Planning Application Reference No.: 3/2014/0090

Address of Development: Area adjacent to 5 Cherry Drive

Address of Development: Land at Eden Gardens(adj 5 Cherry Drive)Brockhall Village Old Langho
BB68HJ

Client MR & MRS PRESTON	Scale 1:100	Sheet Size A3	Job Number 23-019	Drawn By AW	Checked AW
Project LAND ADJACENT EDEN GARDENS PROPOSED DWELLING	Drawing Title PROPOSED ELEVATIONS 2	Drawing Status PLANNING	Drawing Number PL06	Revision C	First Issue -

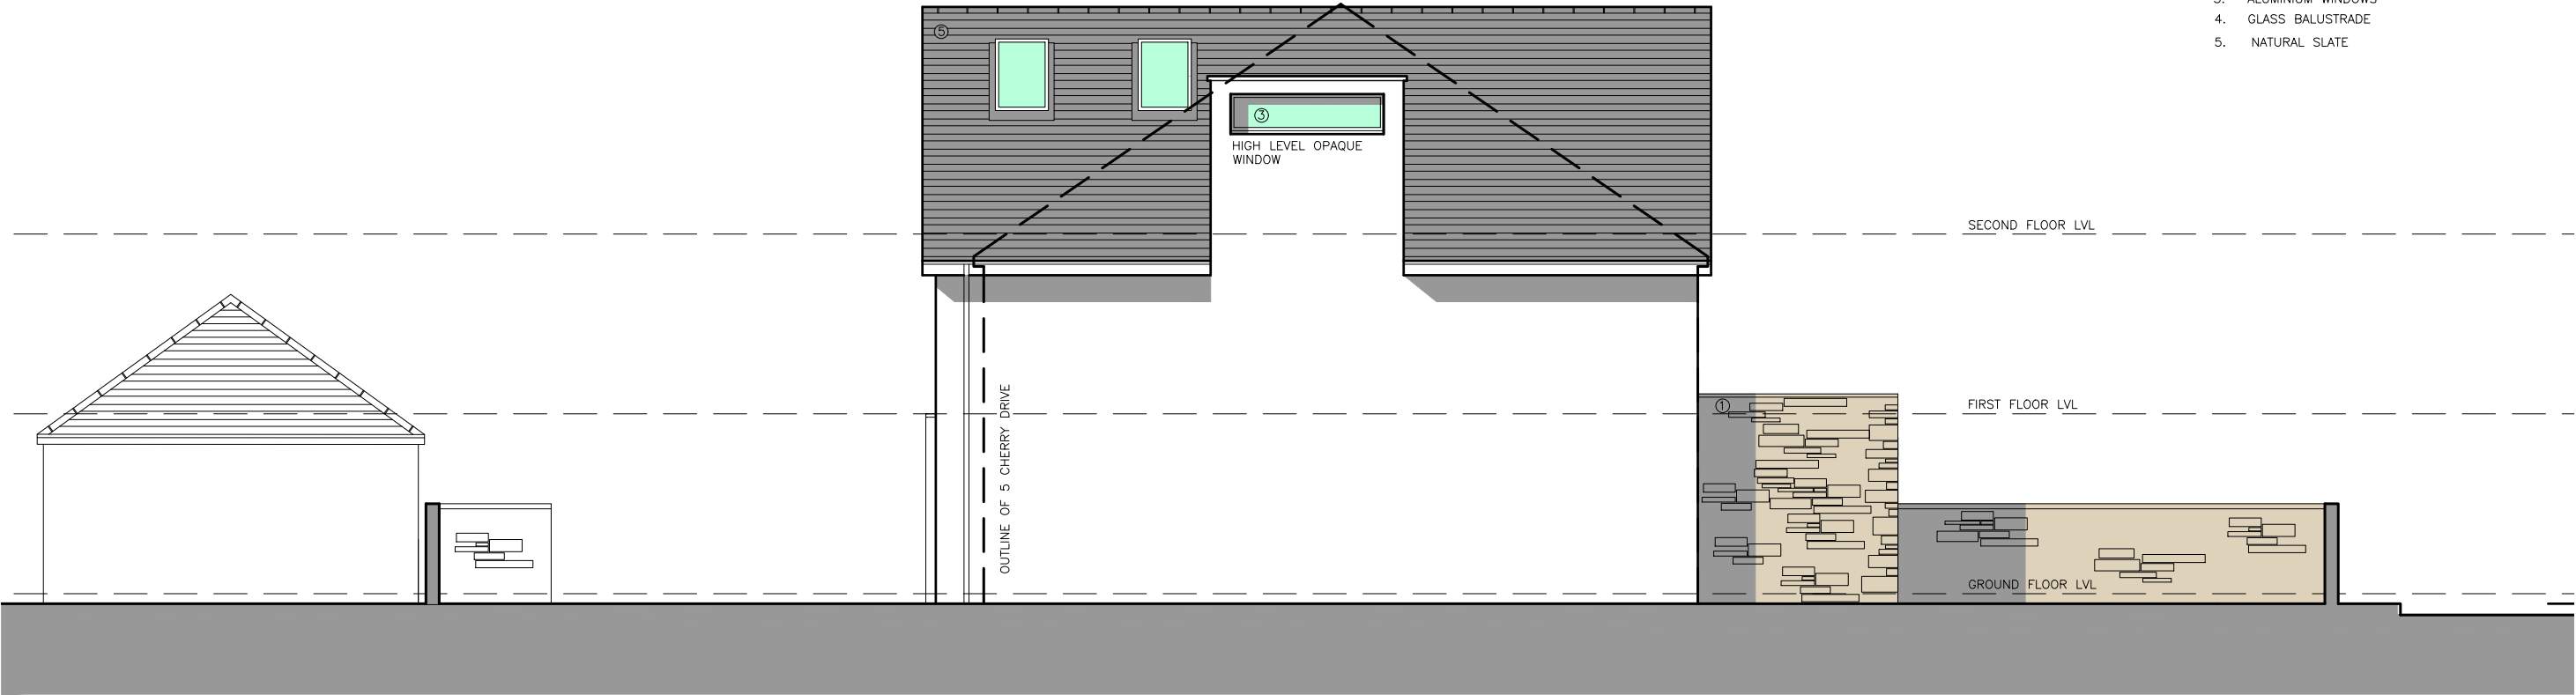
2. The plans include first floor bedrooms with full size Juliette style balcony windows which will [REDACTED]

Client MR & MRS PRESTON	Scale 1:100	Sheet Size A3	Job Number 23-019	Drawn By AW	Checked AW
Project LAND ADJACENT EDEN GARDENS PROPOSED DWELLING	Drawing Title PROPOSED ELEVATIONS 1	Drawing Status PLANNING	Drawing Number PL05	Revision B	First Issue -

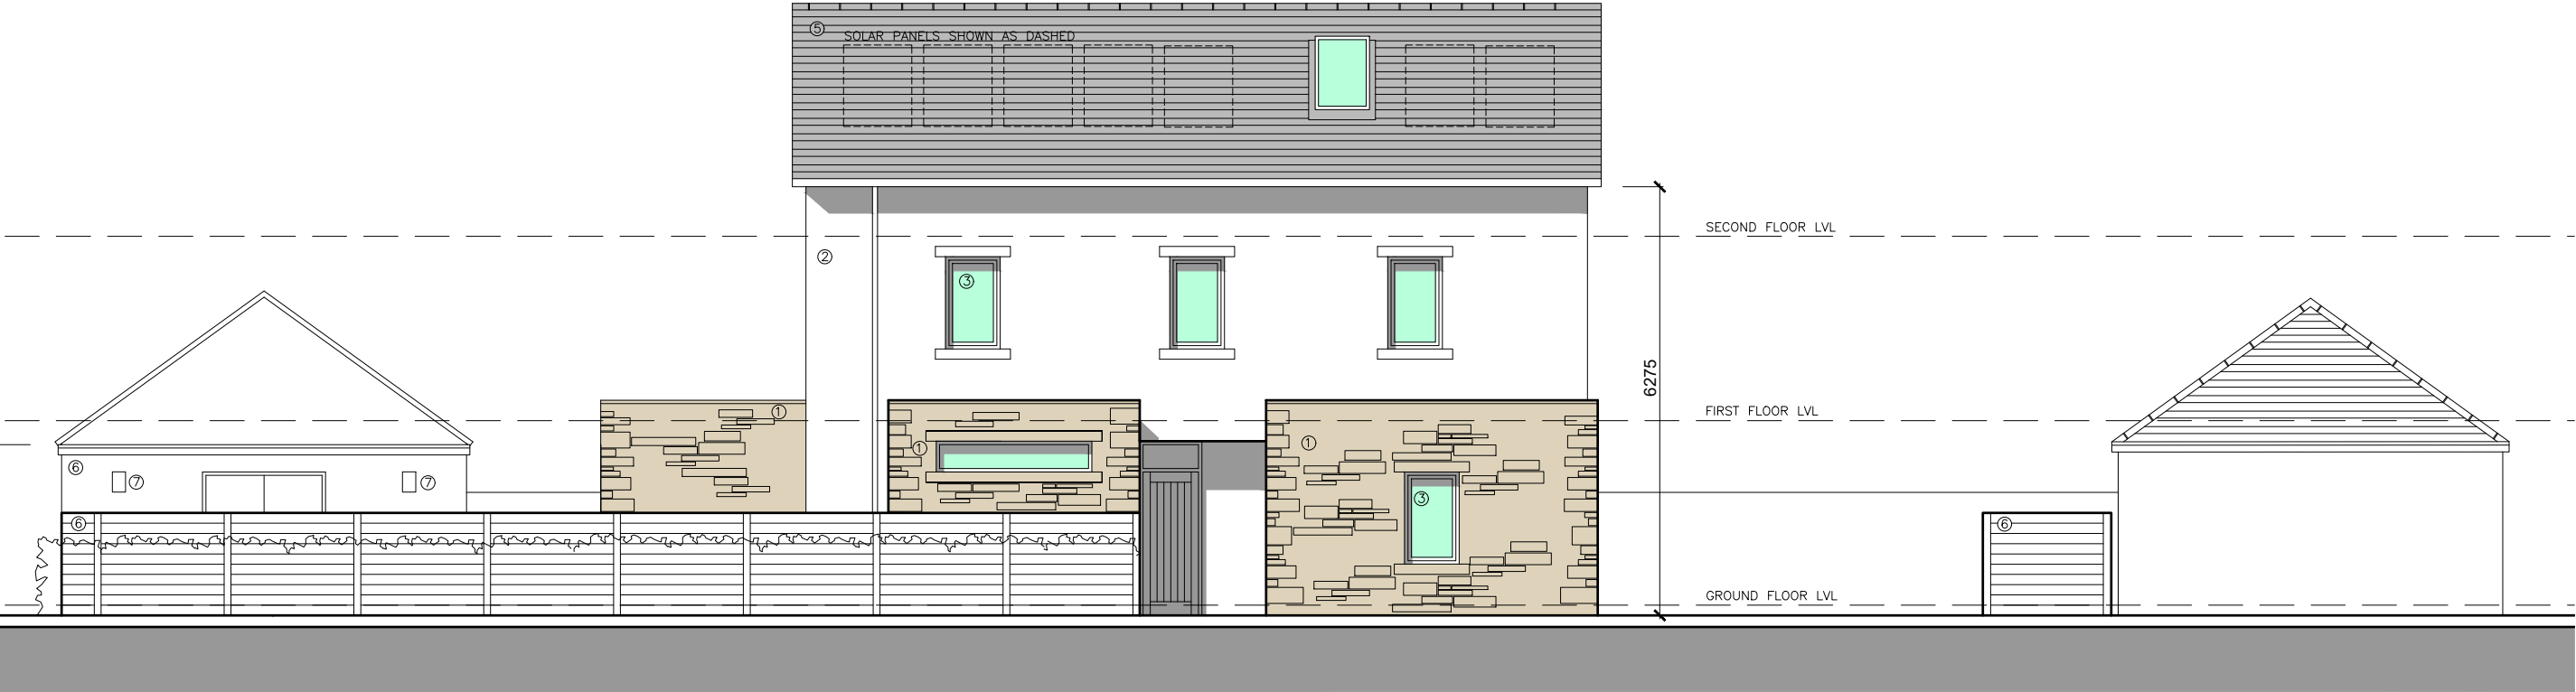
8. The development includes a 1.5m in height composite fence and hedge screening along the front of Cherry Drive and part of Eden Gardens. This 1.5m high fence will reduce the visibility for vehicles coming from Eden Gardens onto Cherry Drive causing a blind spot and potentially hazardous for vehicles and children.
